From: Anita Gardner <Anita.Gardner@arun.gov.uk>
Sent: 08 June 2022 14:54
To: Planning.Responses <Planning.Responses@arun.gov.uk>
Subject: FW: LY/4/22/PL - Crossbush Service Station Lyminster Road Lyminster BN17 7QQ

Application No: LY/4/22/PL
Registered: 21st April 2022
Site Address: Crossbush Service Station Lyminster Road Lyminster BN17 7QQ
Grid Reference: 502841 105804
Description of Works: Variation of conditions following LY/15/21/PL relating to conditions 2-approved plans and 6-external lighting.
National Highways Ref: **HAMIS 94916; Tracker #16812**

Drawn by: JS	Checked by: NIJ
Date: July '21	Scales: 1:200 @ A1
PLAN NO.	201115 - PLNG4 - D
SCALE - METRES - 1:200

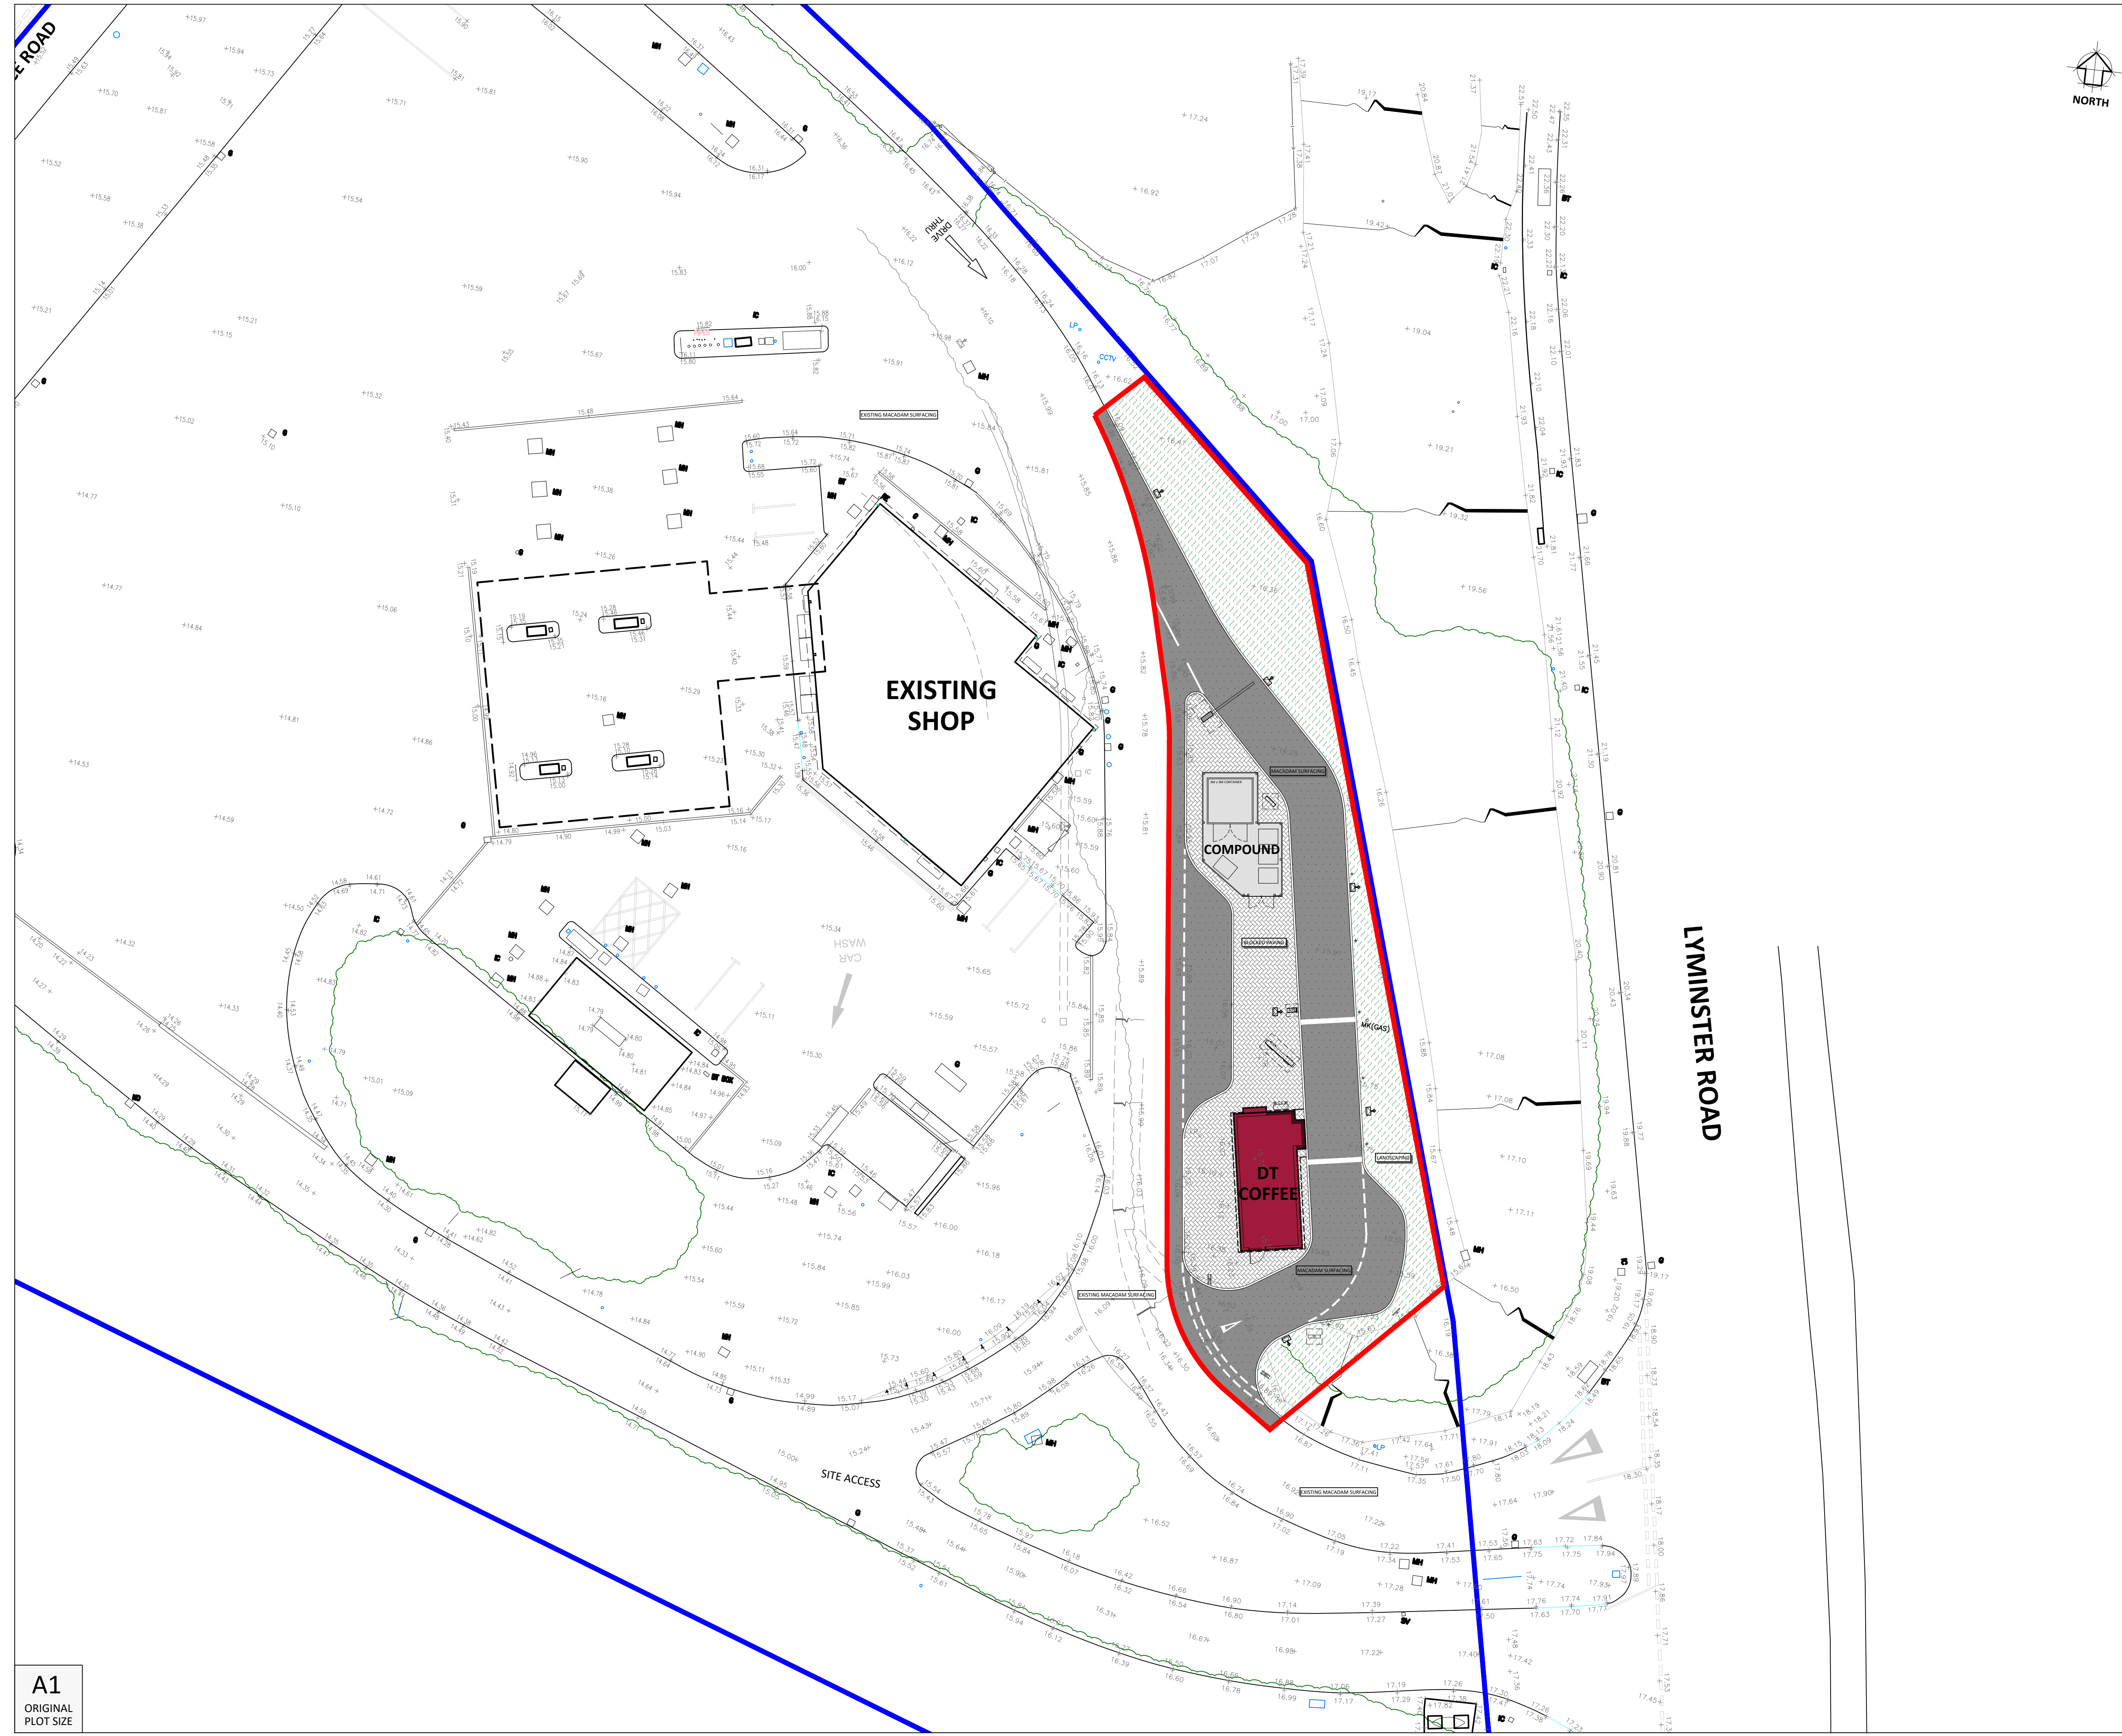
It is noted that the applicant and their team have been in contact with our Arundel Bypass team and have proposed the amendments to attempt to avoid potential clashes with our Bypass works. Whilst we have no objection to either variations it is essential that the applicant and their team continue to keep in close contact with our Bypass team to ensure that they design and co-ordinate their respective works to avoid any clashes. At this time we are concerned that the proposed arrangement creates a pinch point between the Costa development kerb line and our retaining wall in this location. The construction of the retaining wall becomes significantly more complex as a result and could impact upon both schemes. In addition, we are currently required to divert the 11kV cable (this may change following on-going dialogue with the service owner) which runs underneath the new development. We anticipate in constructing the proposed development the applicant would also need to divert due to the shallow depth of the service. It is unclear whether the applicant is aware of this or if they have engaged with the requisite utility provider. If we are required to complete a diversion then it is likely that significant portions of the recently completed development would be directly impacted in order to complete this work with the potential for wider impacts depending on the final location of the relocated cable route. Finally, we are at this stage unclear as to what requirements, if any, the new development would have in terms of provision of other services (gas, water, foul etc) and the associated citing. Accordingly, we are unclear as to whether these would have a further impact on our new retaining structure.
